Rezoning Transportation Analysis

Petition Number: #2022-084

Revision Log:

Date	Description
11-28-22	First Review (TM)

**SCHEMATIC**  
**SITE PLAN**

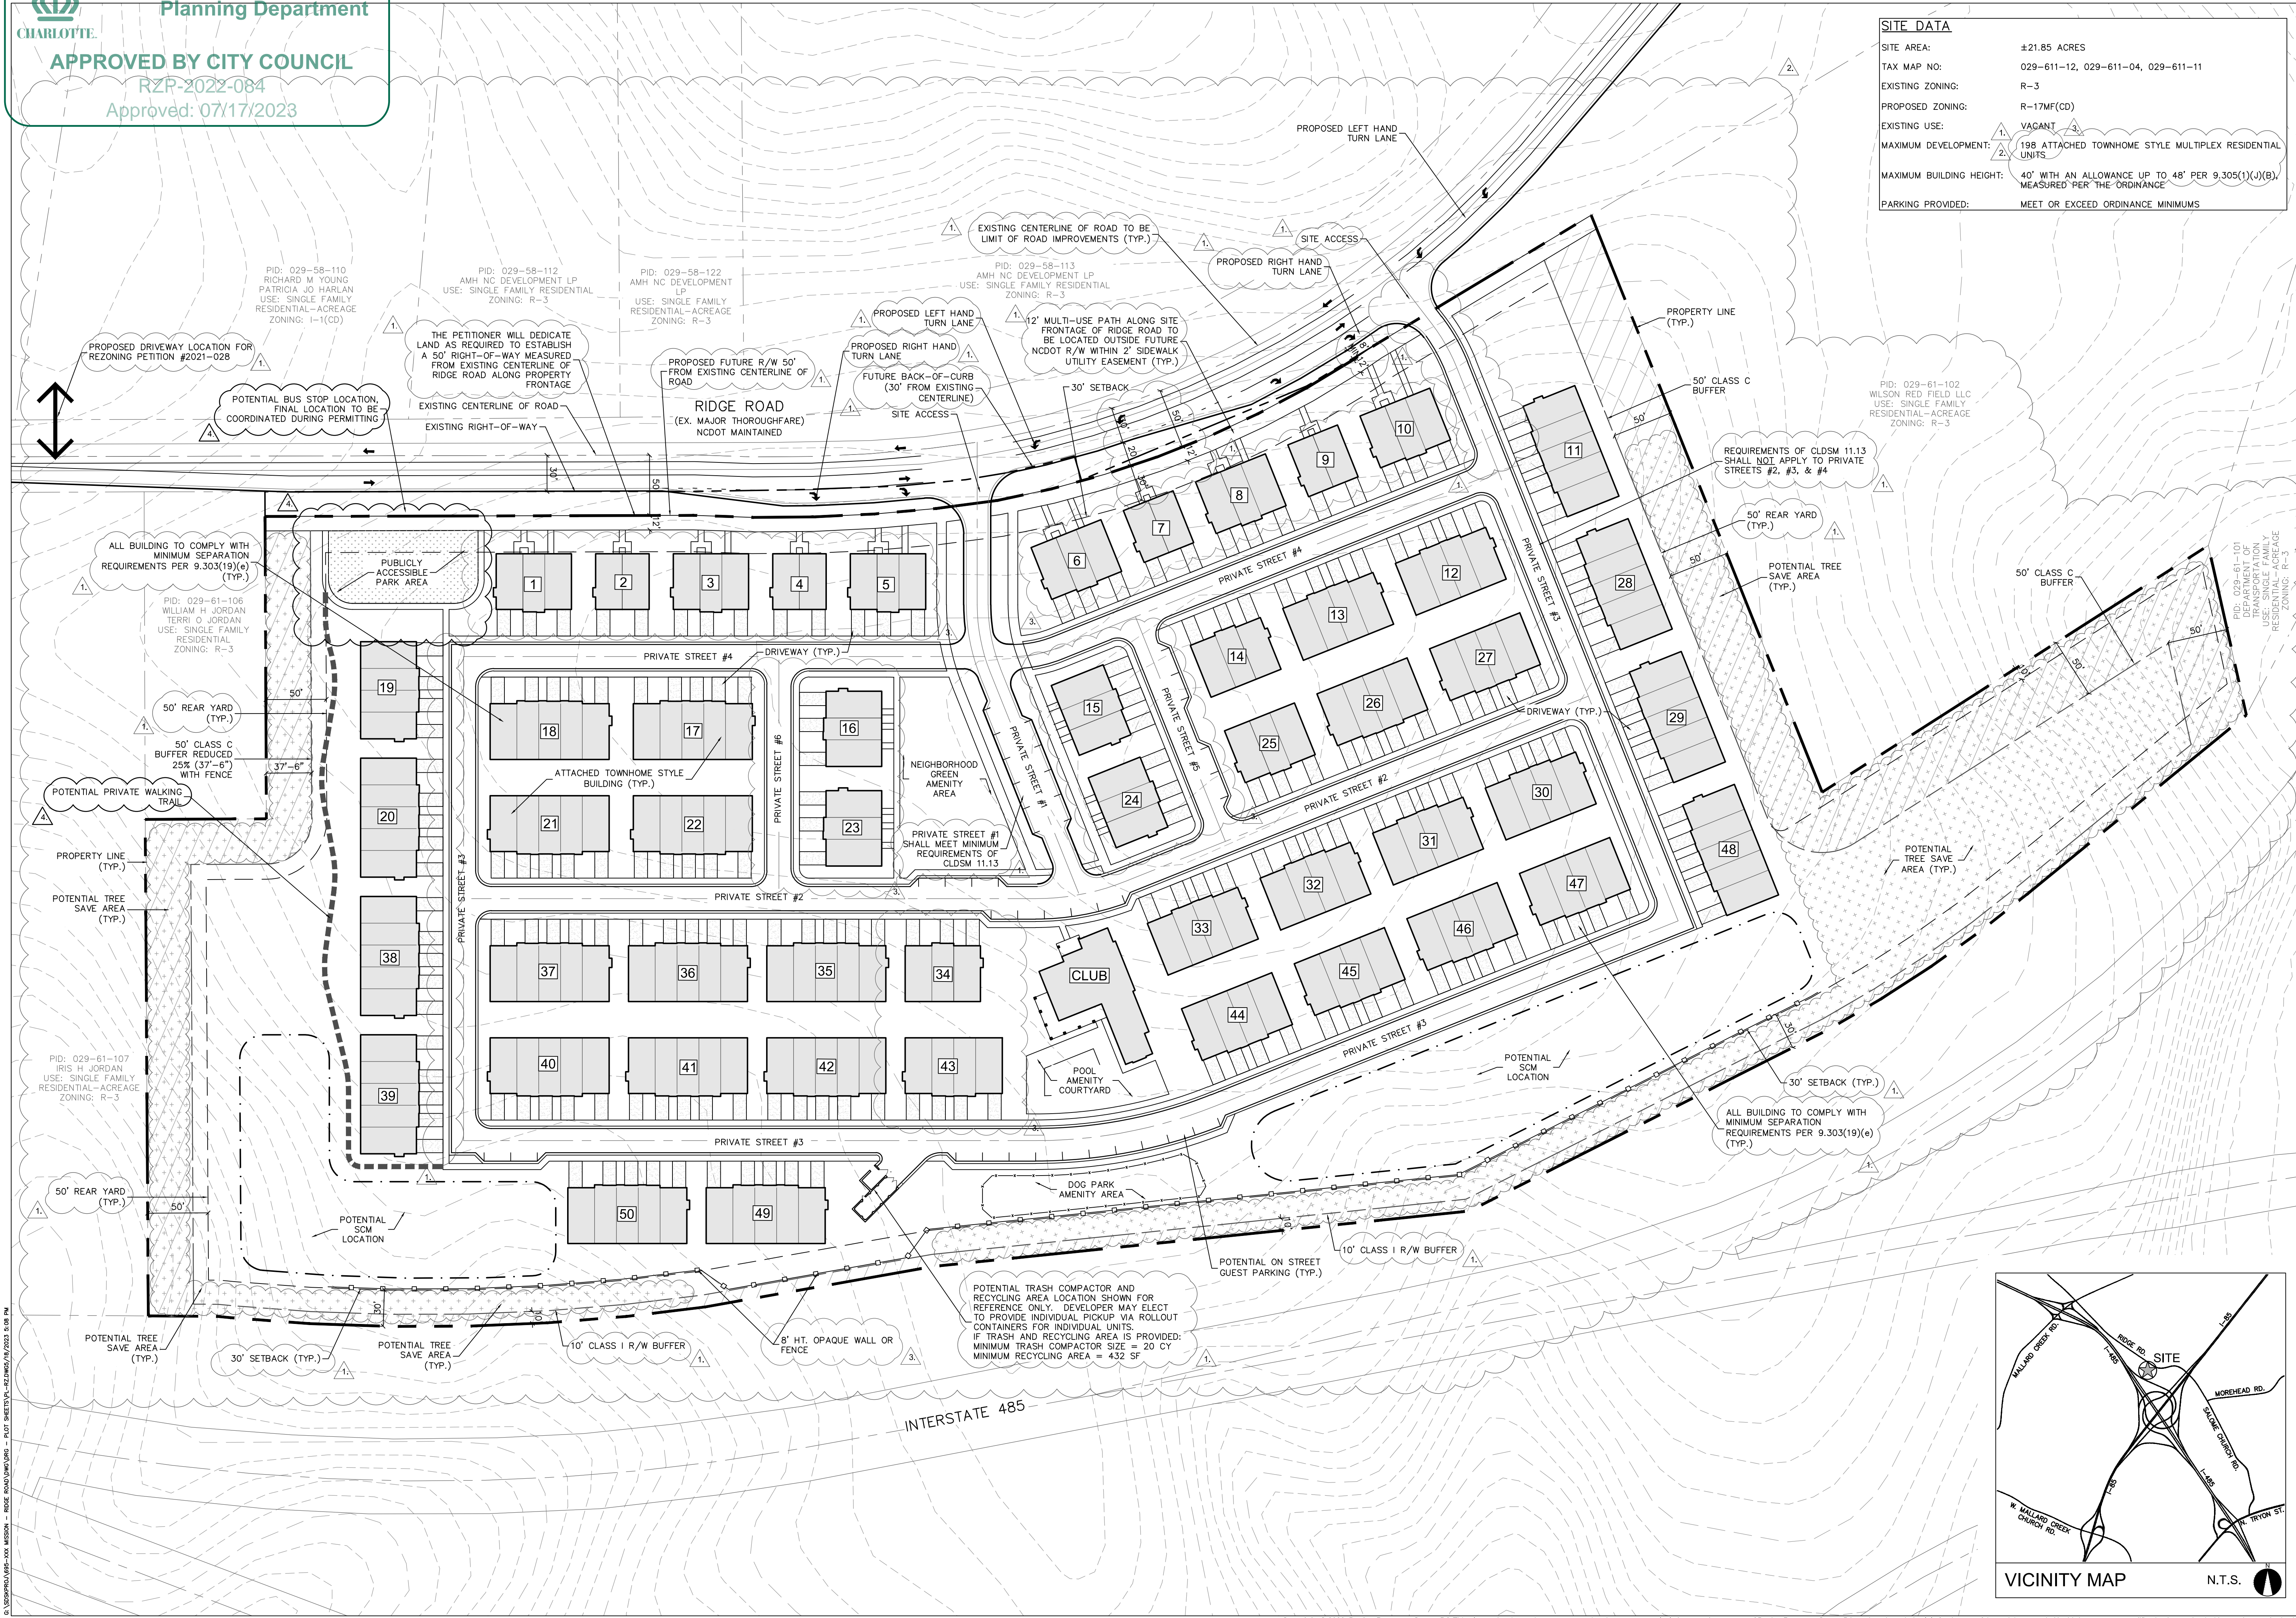
1. **Curblines:** The proposed zoning district has a setback measured from back of the existing or proposed future curblines.
 - a. **Ridge Road:** The future location of curb and gutter is measured at 30-feet from the centerline of the roadway to the BOC.

Label and dimension the curb and gutter from the centerline for each road on the site plan.

2. **Traffic Study:**
A Traffic Impact Study (TIS) is not necessary for the complete review of this petition due to the site generating less than 2,500 daily trips. If during the permitting process the site generates more than 2,500 daily trips, then a traffic study will be required.
3. Revise site plan and conditional note(s) to commit to dedicate 50-feet of right-of-way from the road centerline. The site plan shall label and dimension the right-of-way from the road centerline.
4. Site plan and conditional note(s) revisions are needed to commit to constructing internal private roads to meet or exceed CLDSM standard 11.13. Site plan shall callout CLDSM 11.13 and add roadway cross section detail.

5. Site plan and conditional note(s) revisions are needed to commit to constructing a full three lane section on Ridge Road along the site frontage. 3-lane section to include a two-way left turn lane along the site frontage and two through lanes. Dimension the transition length and width of the two-way left turn lane along Ridge Road per NCDOT comments.

6. Site plan and conditional note(s) revisions are needed to commit to constructing a right-turn at both driveways per NCDOT comments.
7. Site plan and conditional note(s) revisions are needed to commit to aligning site entrances with the Kings Grant rezoning (2021-028). Site plan shall show linework from Kings Grant development along Ridge Road.

11. Revise site plan to construct a 12-foot multi-use path on Ridge Road. The site plan shall label and dimension both items from the back of curb and gutter and road centerline. The entire facility must be outside of the right of way and within a public access easement. Add conditional note committing to construction and maintenance of the 12-foot multi-use path on Ridge Road.
